**EL PASO COUNTY PLANNING AND
 COMMUNITY DEVELOPMENT
 DEPARTMENT**

GRADING AND EROSION CONTROL PLAN CHECKLIST

EL PASO COUNTY, STATE OF COLORADO GRADING & EROSION CONTROL PLAN

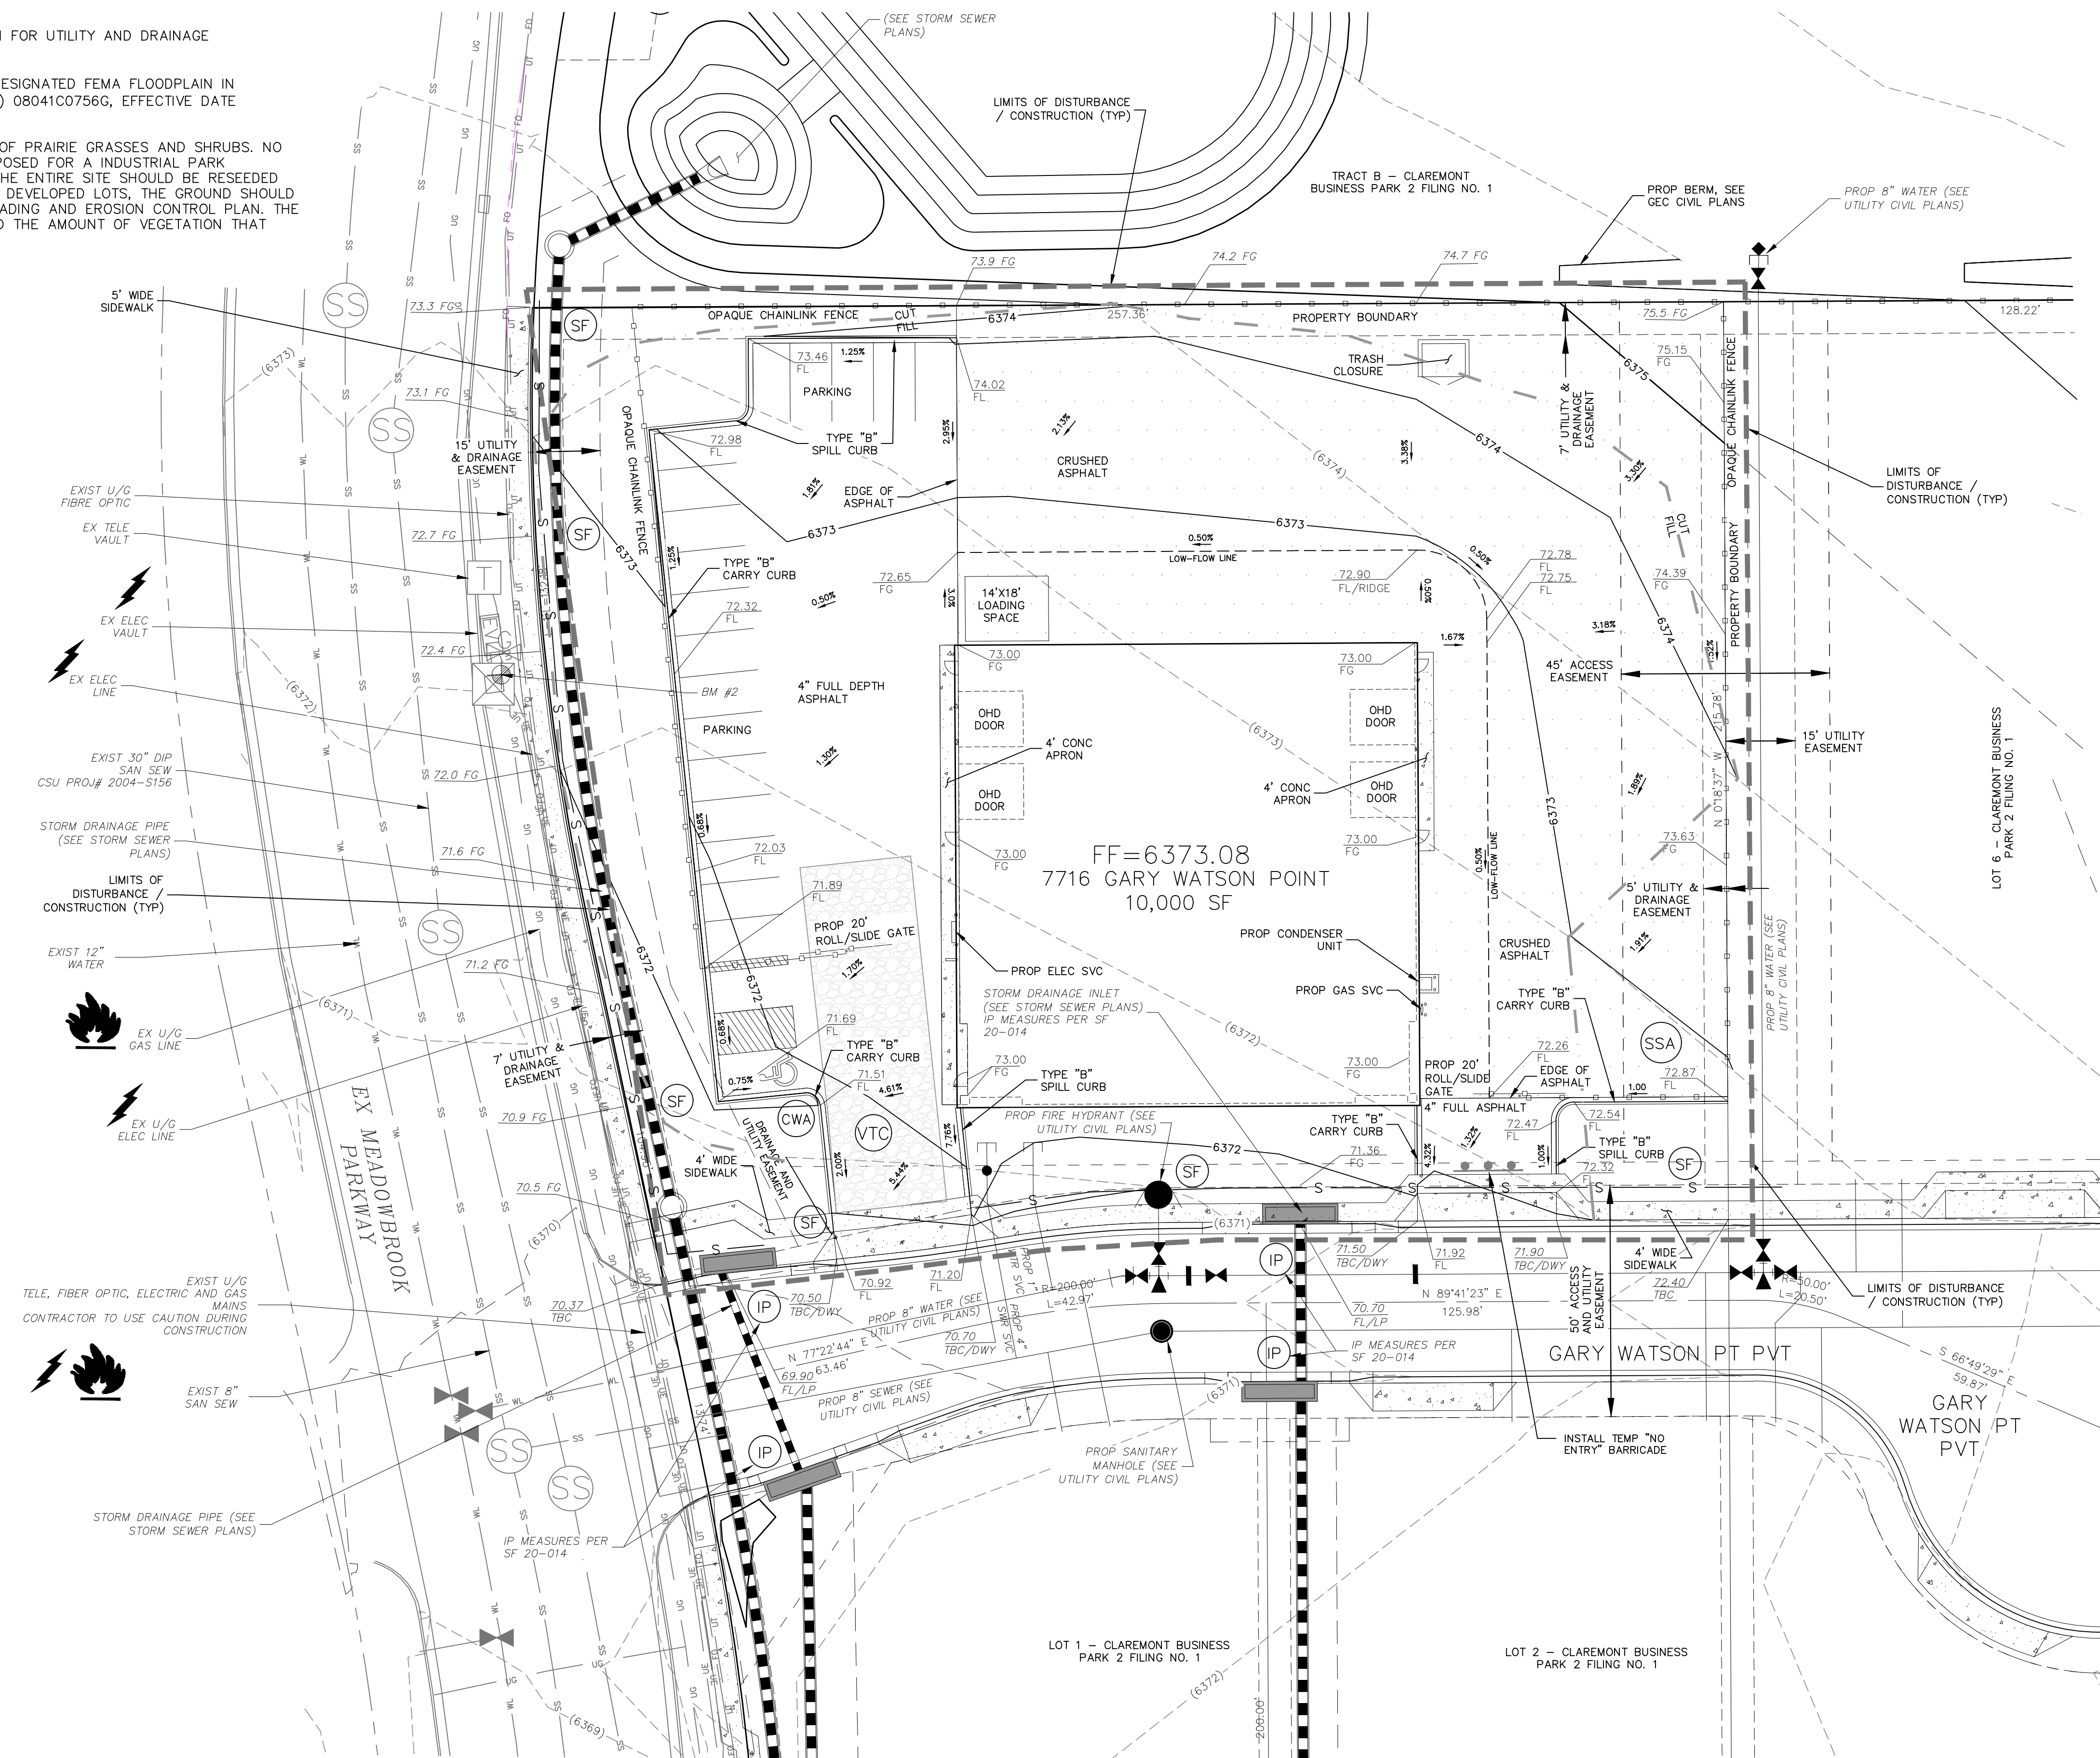
| | | Applicant | PCD |
|--|---|-----------|-----|
| d | Legend for all symbols used in the plan. Add drainage flow arrows to Legend | X | X |
| h | Construction site boundaries. | X | X |
| i | Existing vegetation (notes are acceptable in cases where there is no notable vegetation, only grasses/weeds, or site has already been stripped). | X | X |
| p | Areas of cut and fill identified. | X | X |

Vehicle Tracking Control (VTC) SM-4

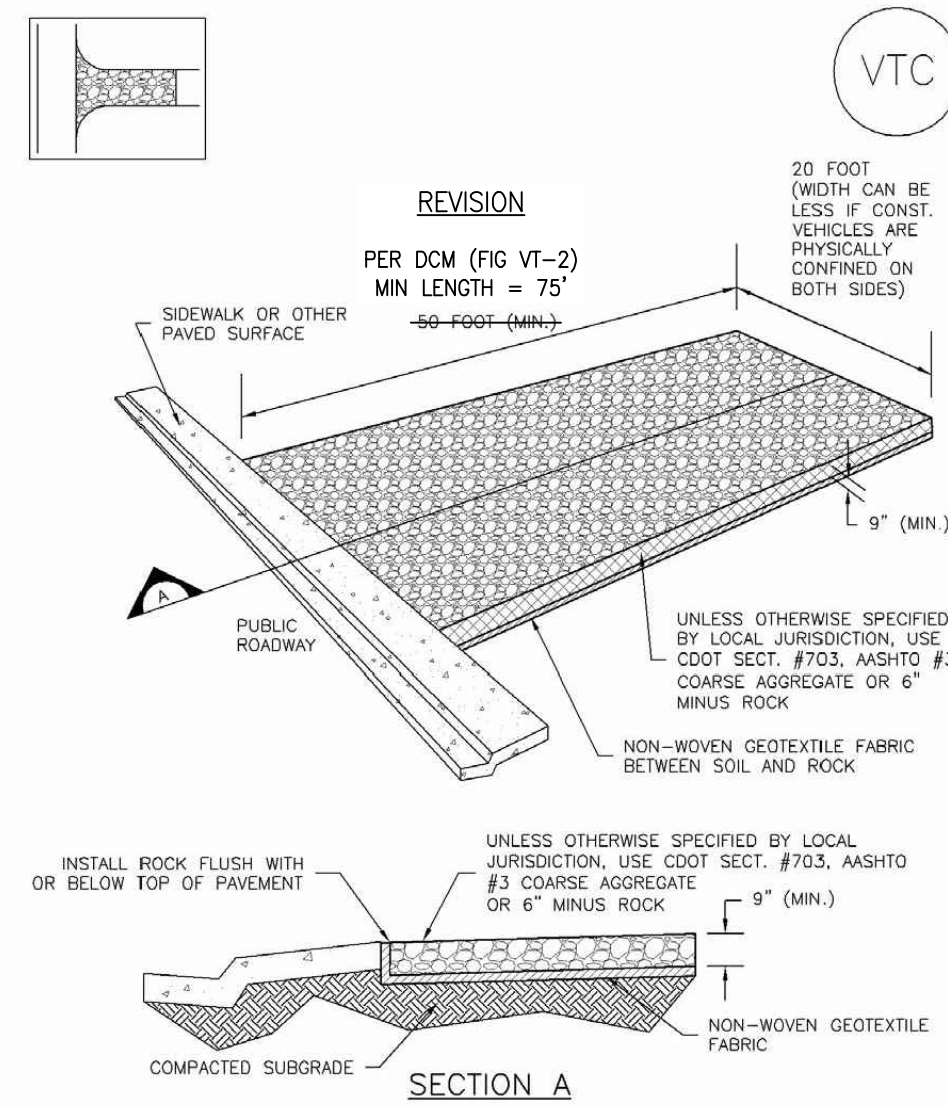
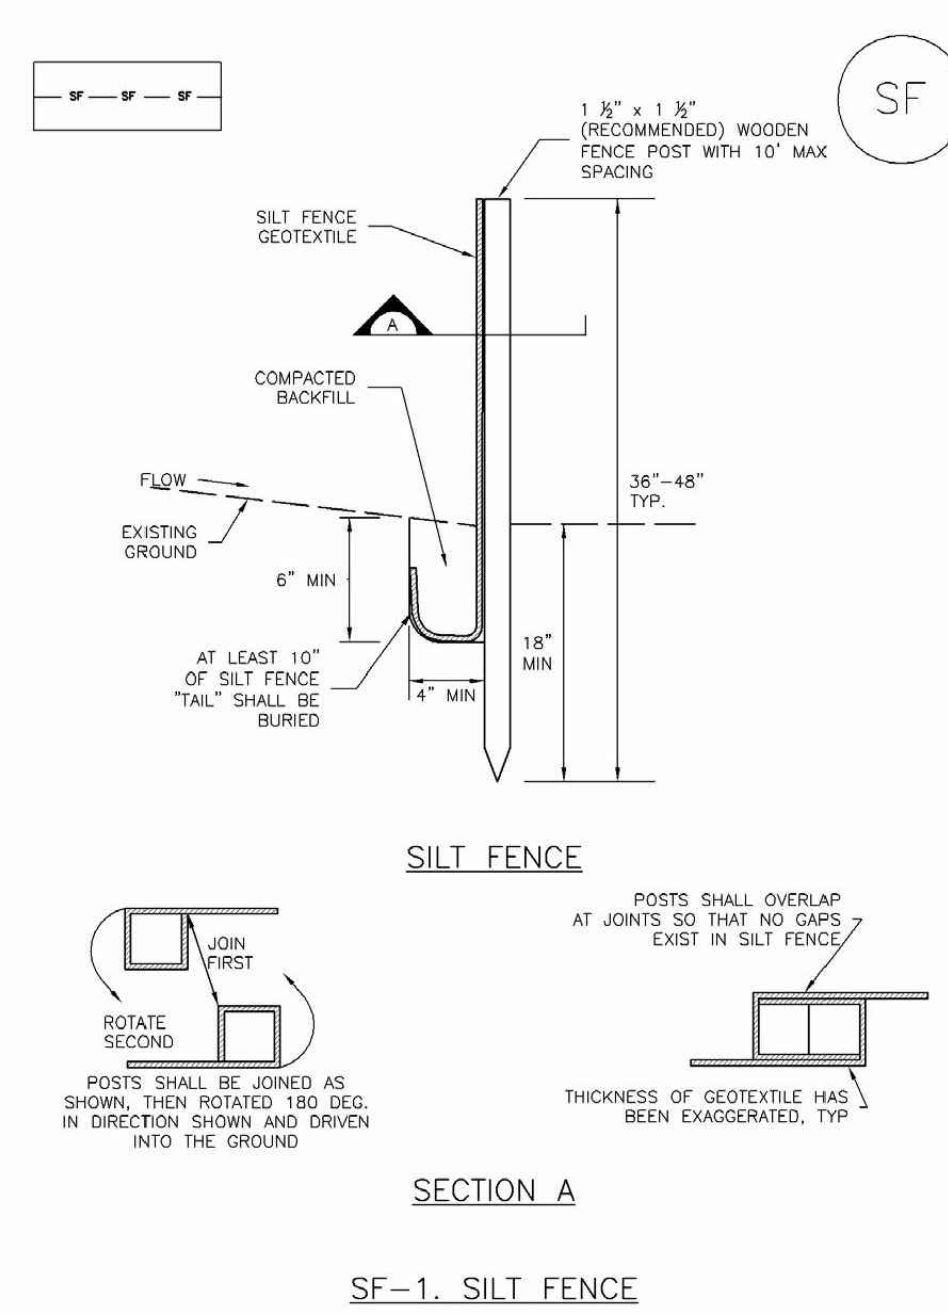
| | | Applicant | PCD |
|--|---|-----------|-----|
| z | All proposed temporary construction control measure details. Custom or other jurisdiction's details used must meet or exceed EPC standards. | X | X |
